A47 DUALLING – NORTH TUDDENHAM TO EASTON

SUMMARY OF SUBMISSIONS

At ISH2 (4-5 Nov 2021)

and Technical Note of RPS Consulting

Figure 2-3: Wood Lane Junction Alternative 1

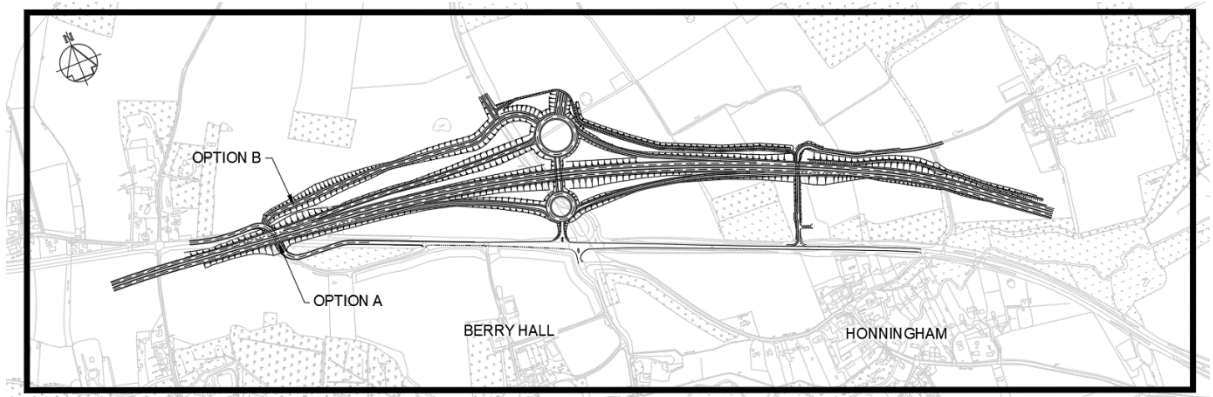
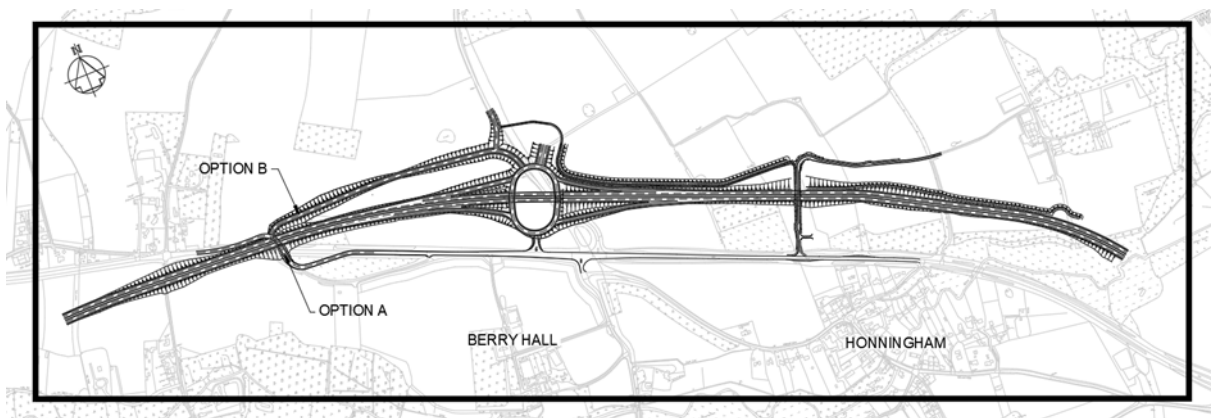
- a. First, with regards to the mainline:
- i. The Applicant states that it will require raising to accommodate the Lady's Grove underpass proposed. This is not true, however, as the existing A47 to the west of the proposed underpass is at a lower level. It is technically possible to get under the A47 at the crossing point without raising the mainline levels from those currently proposed by the Applicant.

- ii. The second point with regards to the mainline is the possibility of the need to widen the mainline to accommodate driver sightlines. Any such widening would be very minor, about 0.5m to 1m, and would all be within the existing red line (DCO) boundary.

- iii. The third point with the mainline is that the slip roads would have to be lengthened, but if needed this could be done very easily, whilst remaining within the red line boundary.

- b. The second main issue raised in the Applicant's appraisal was side roads. Our response to this critique is that the alternatives proposed by ACM accommodate the Applicant's approach to Berry's Lane (i.e. its closure [in the alternatives, south of its junction with the then retained Dereham Road]).

- c. The final main issue raised in the Applicant's appraisal was vertical alignment. It is not accepted that ACM as an objector is required to provide a design incorporating vertical alignments at this stage. ACM does not have the resources of the Applicant and is only presenting alternatives which should be considered.
